Ribble Valley Borough Council
By email

Your ref: 3/2022/0568
Our ref: DC/22/2631 v2
Date: 01-FEB-23

Location: Land to rear of Malt Kiln House Malt Kiln Brow Chipping PR3 2GP
Proposal: Four new, two-storey residential dwellings.

United Utilities wish to make the following comments regarding the proposal detailed above.

DRAWING TITLE
Drainage Strategy.

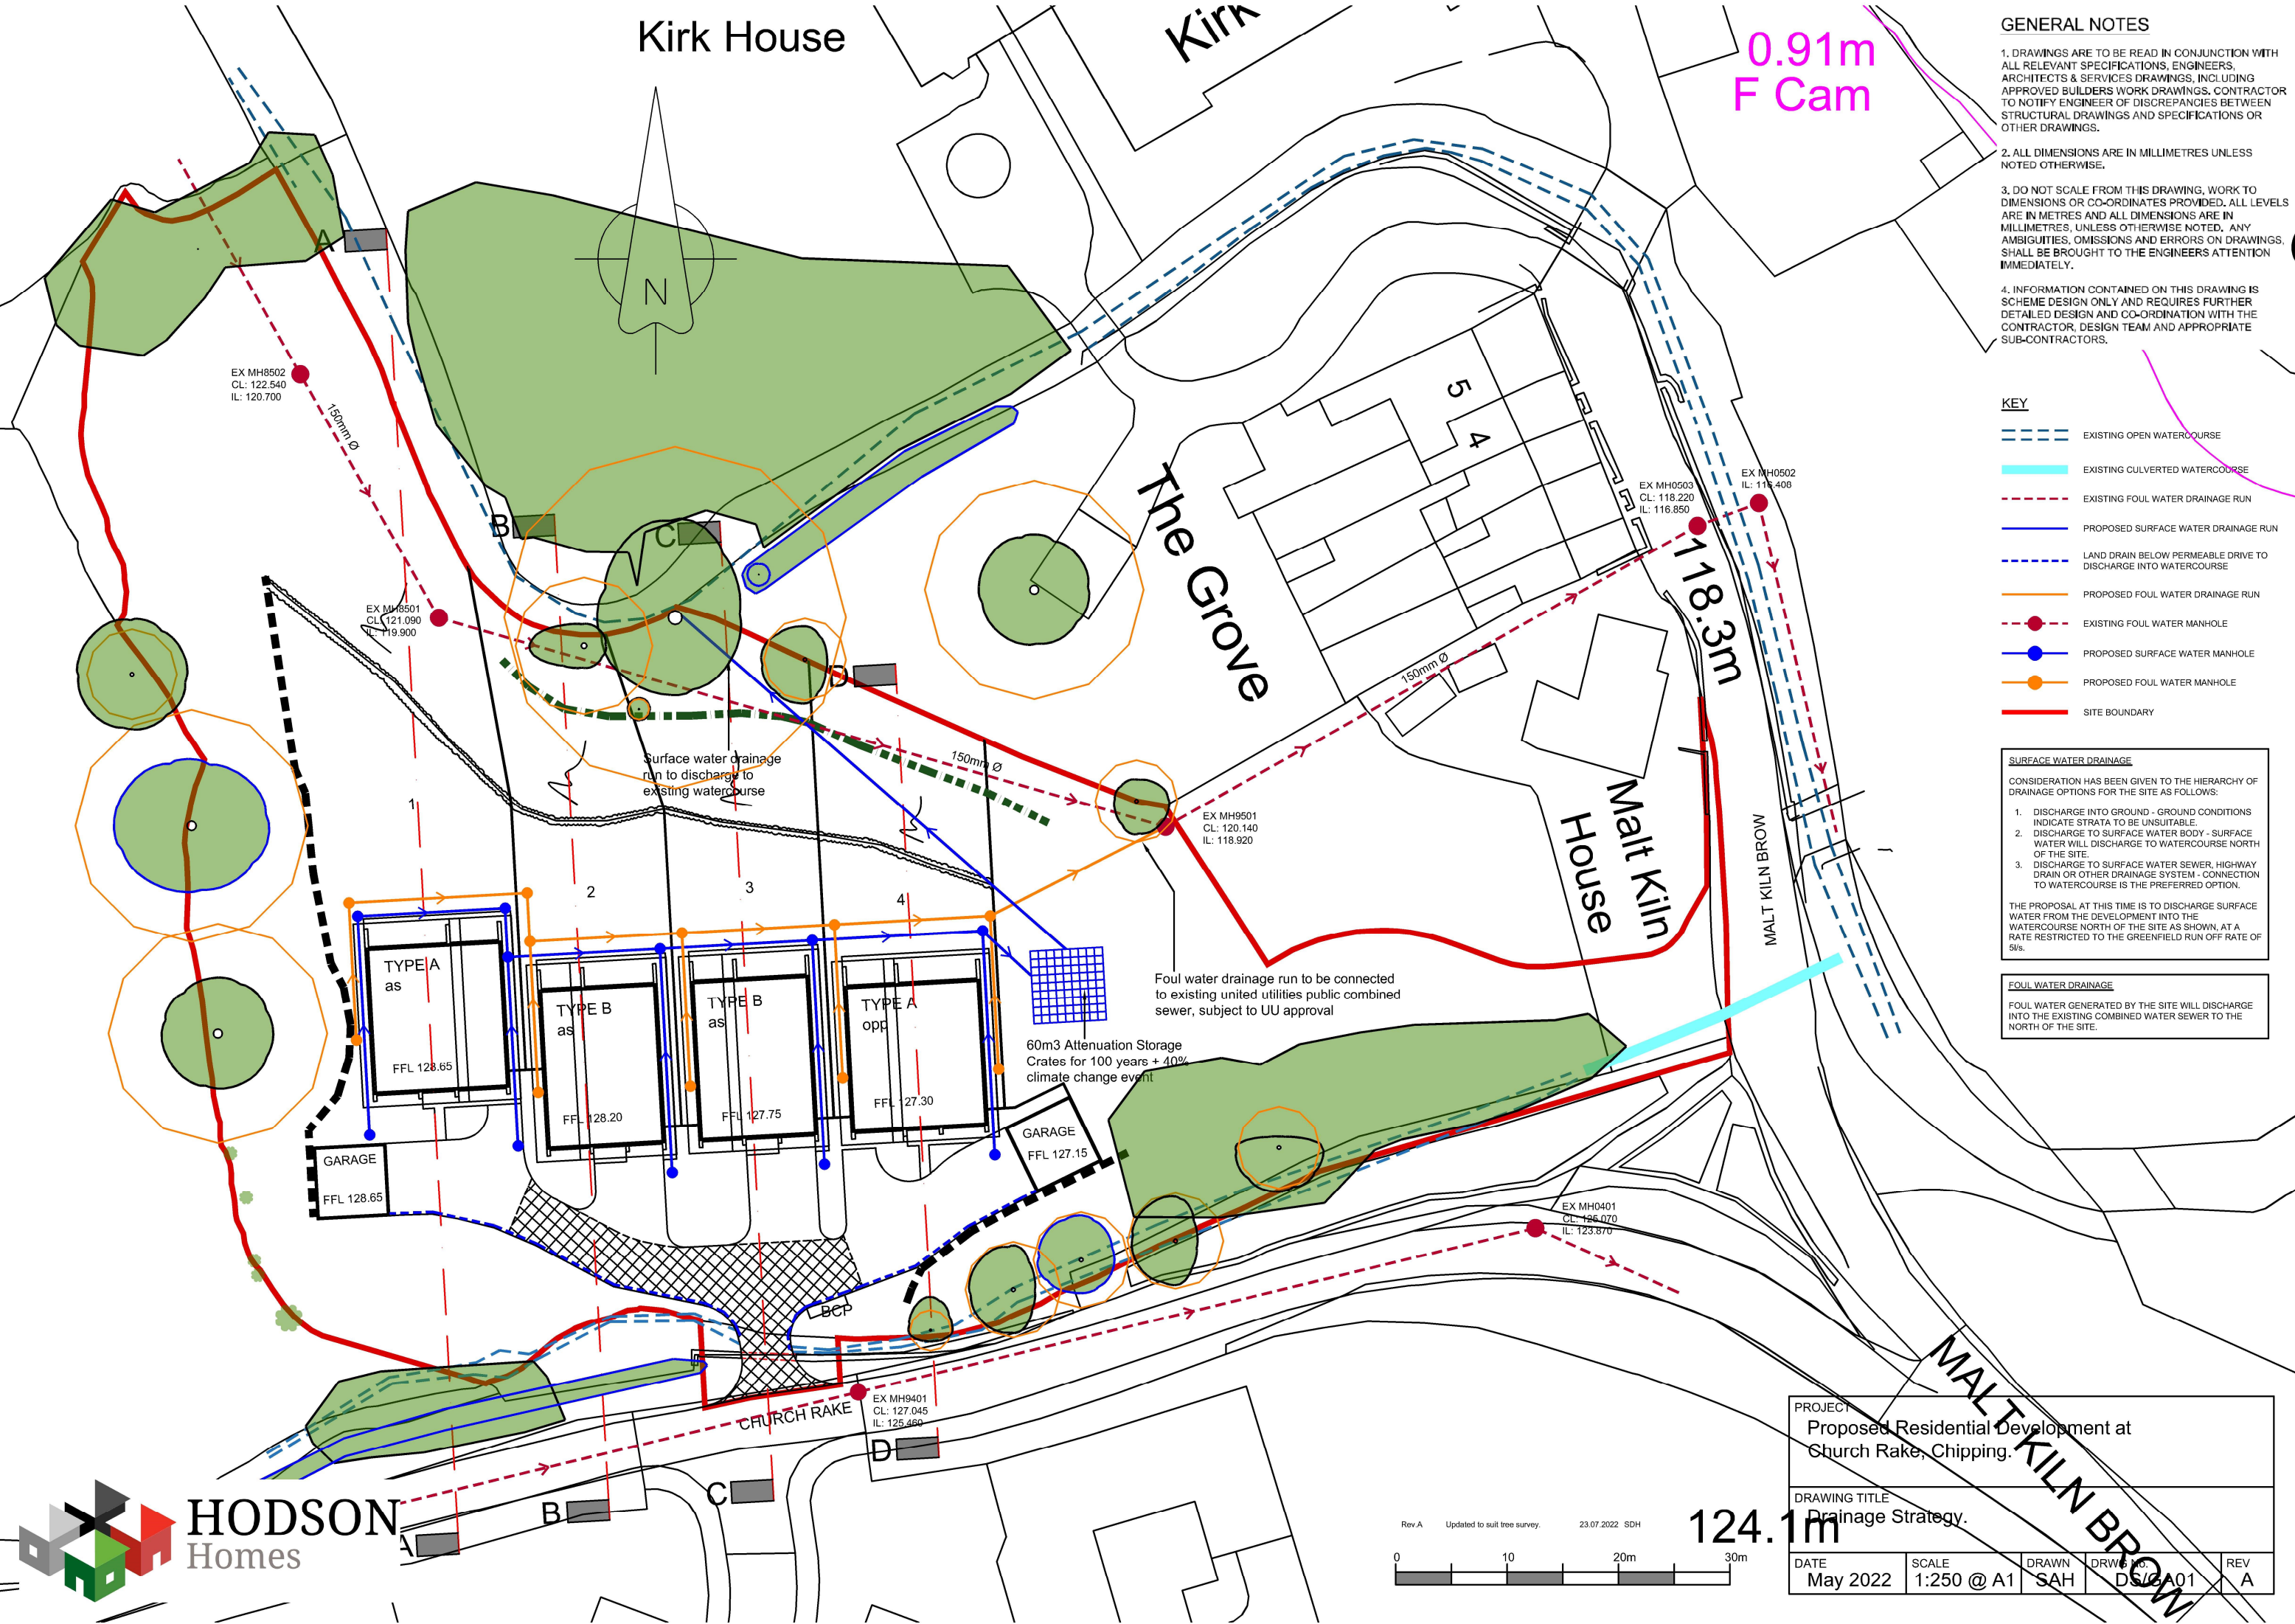
Following our review of the submitted Drainage Strategy, we can confirm the proposals are acceptable in principle to United Utilities and therefore should planning permission be granted we request the following condition is attached to any subsequent Decision Notice:

The drainage for the development hereby approved, shall be carried out in accordance with principles set out in the submitted Foul & Surface Water Drainage Design Drawing DS/GA01, Rev C - Dated 28.12.22 which was prepared by MALT KILN BROWN. For the avoidance of doubt no surface water will be permitted to drain directly or indirectly into the public sewer. Prior to occupation of the proposed development, the drainage schemes shall be completed in accordance with the approved details and retained thereafter for the lifetime of the development.

A public sewer crosses the site and we will not permit building over it. We require an access strip for maintenance or replacement. The minimum distances that might be acceptable to United Utilities are detailed within Part H of the Building Regulations however, we recommend the applicant determines the precise location, size, depth and condition of the pipeline as this is likely to influence the required stand-off distance from any structure.
